Permit Number: 060902

This is to certify that BYRNE SMITH TUTTLE INC/Nate Nelson
has permission to Dwelling 8'x11' two story addition w/ 5' deck on 1st level & 5'x13' deck on upper level & 2 dormers
AT 85 PRINCE AVE 091 R008001

From: Tammy Munson
To: port-web:gwdesign@[adelphia.net]
Date: Mon, Aug 28, 2006 11:50 AM
Subject: Re: Prince Ave

Re: 85 Prince Ave / Peaks Island
" Firefly "

2 DET. @ NEW BALCONY

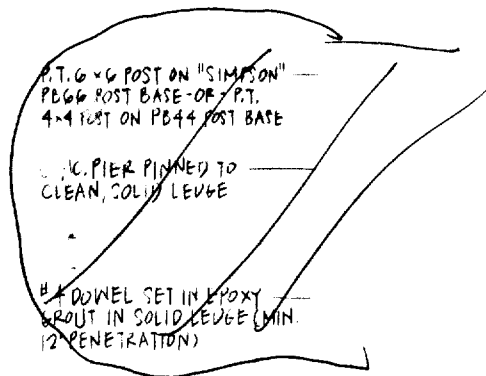
1. Stair details on replacement stairs
2. Double Grider on 2nd floor deck (refer to 2/A4)
3. The electrical panel is not allowed to be located in the bathroom. It should be relocated if possible.
4. Dormer framing details
5. Header Schedule
6. If all windows are being replaced, any within 2' of a door shall be tempered and any in the stairway.
I should be here this week until Wednesday so if you can get this to me asap hopefully we can get this one done. You can fax the info is it is easier.

- ✓ 2. 2nd floor deck girder: doubled up p.t. 2x8 will be spaced 6' 8" from new addition and 6'4". This will allow 4x4 p.t. post to support weight directly down to concrete piers shown on prints. 2x6 p.t. joist will run on girders shown on prints.
